FRAMING DIAGRAM FOR NEW FLOOR & PARTITION WALLS

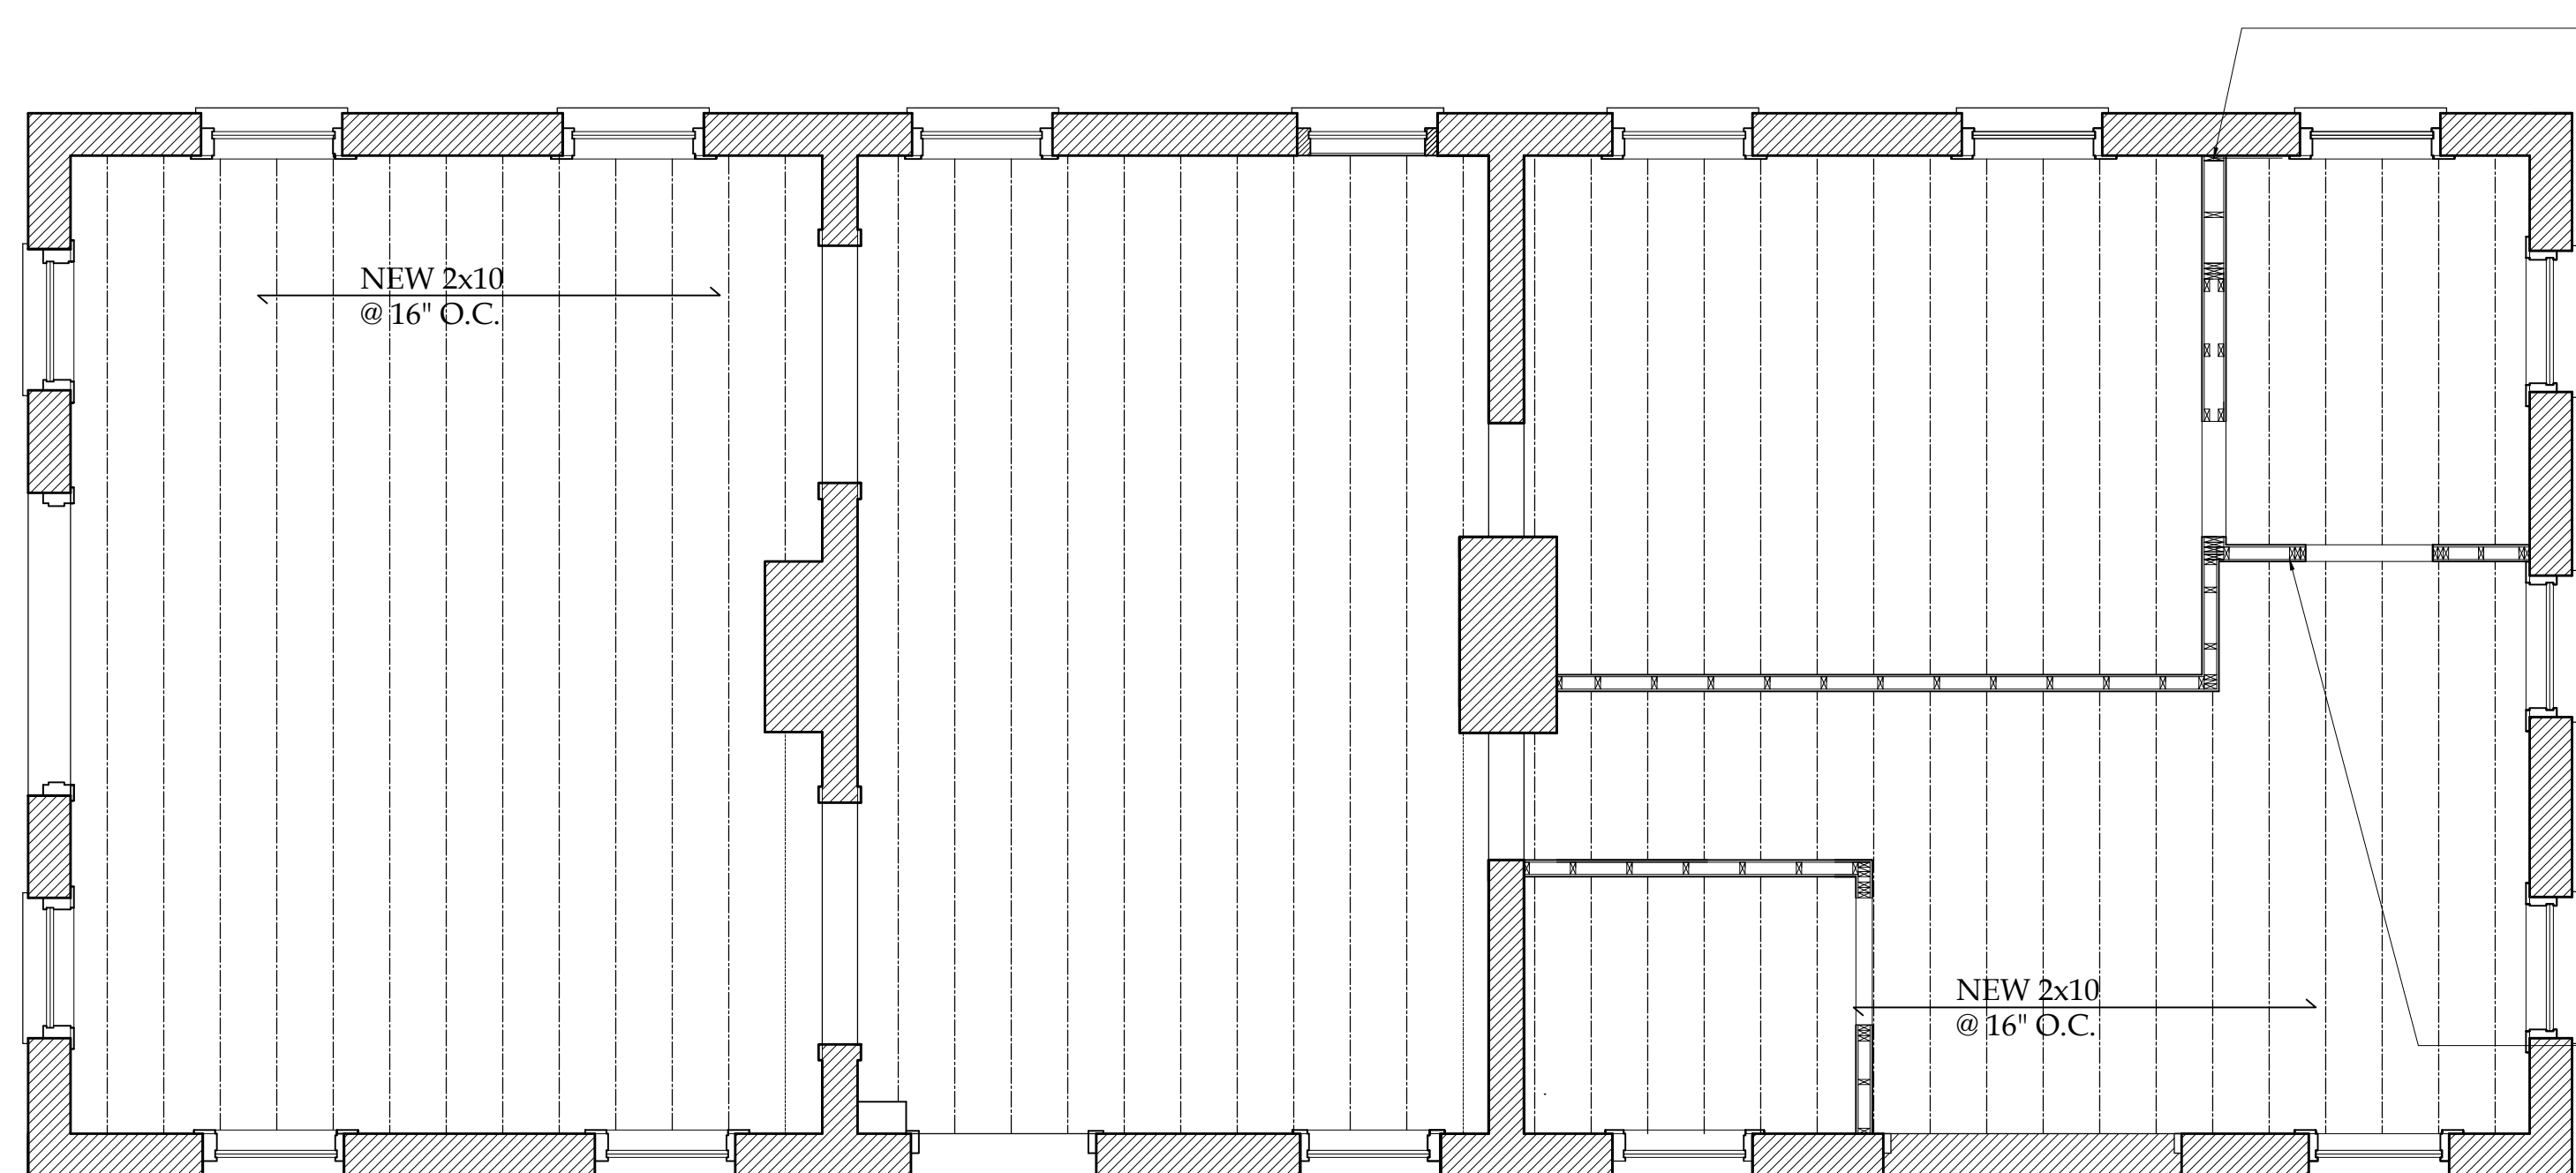
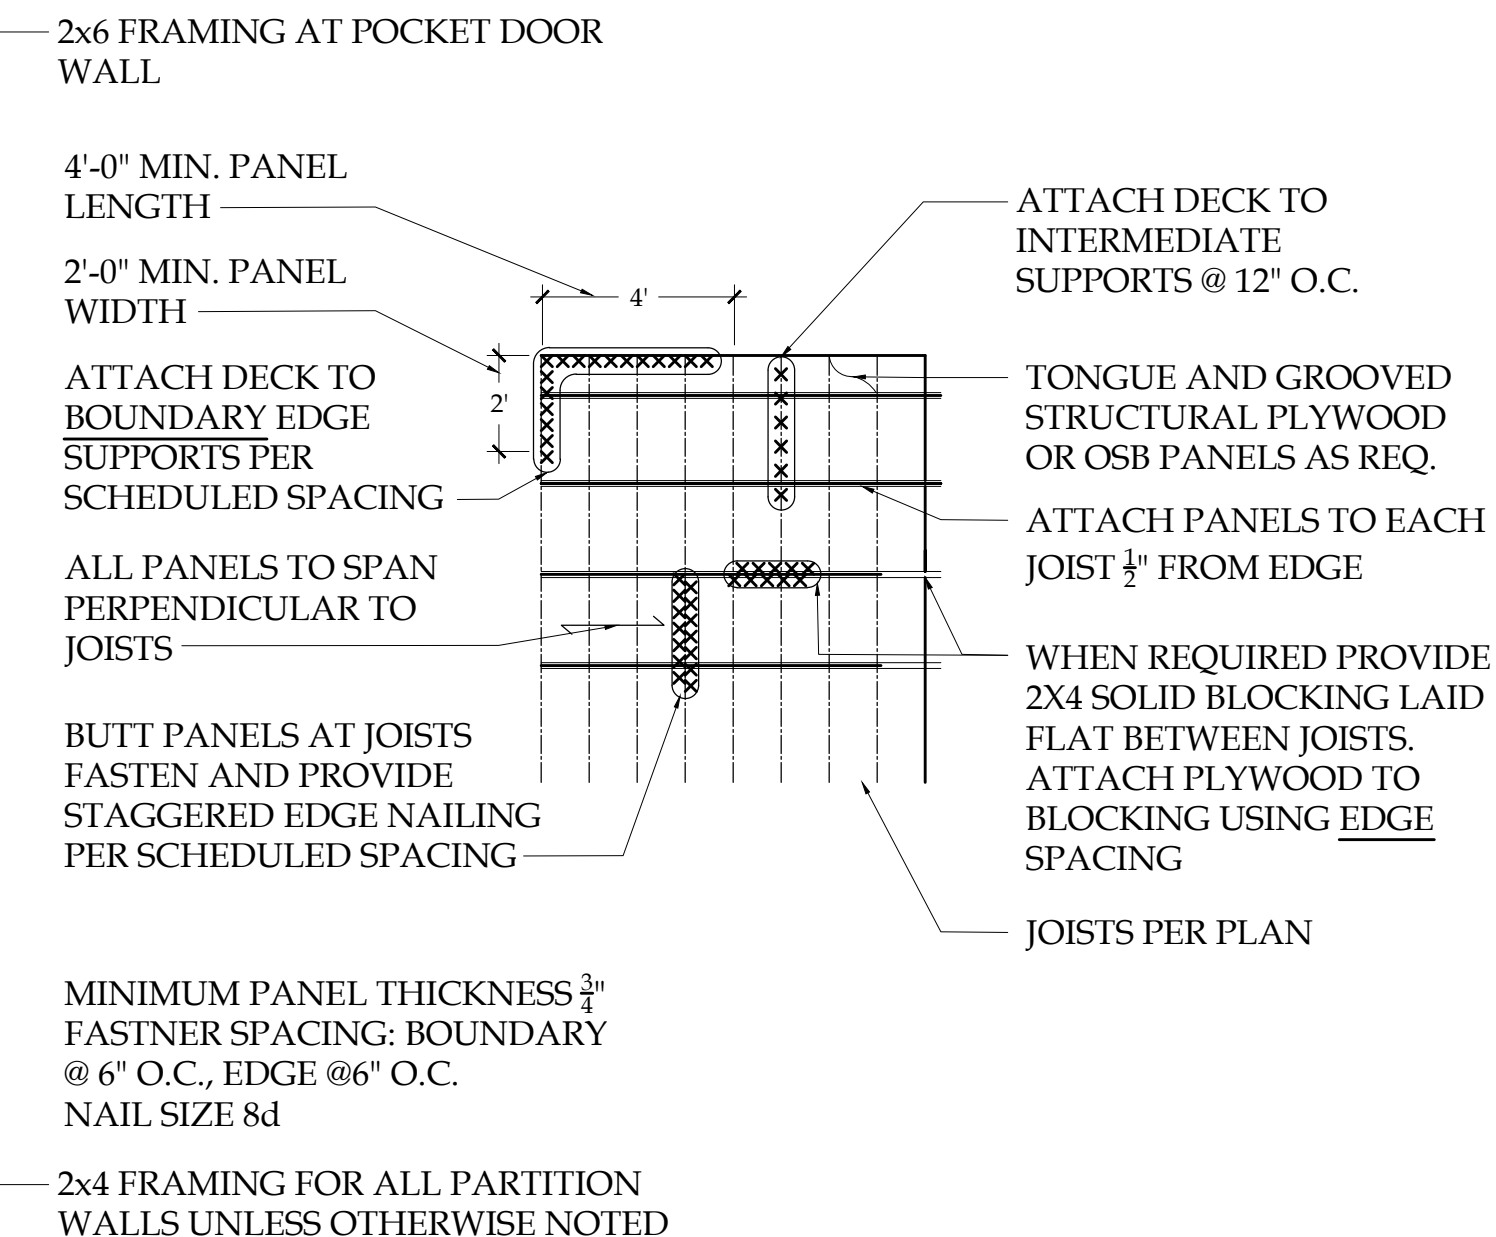
Please show building section with framing spans, sizing, spacing, blocking and connection details.

Please provide structural plans, sections and details stamped by a professional engineer including (but not limited to) the following:  
1. Extent and details of any concrete and/or masonry work.  
2. All new framing (girders, beams, headers, joists, posts, studs, etc.) with sizes, spacing, spans, blocking and connection details.
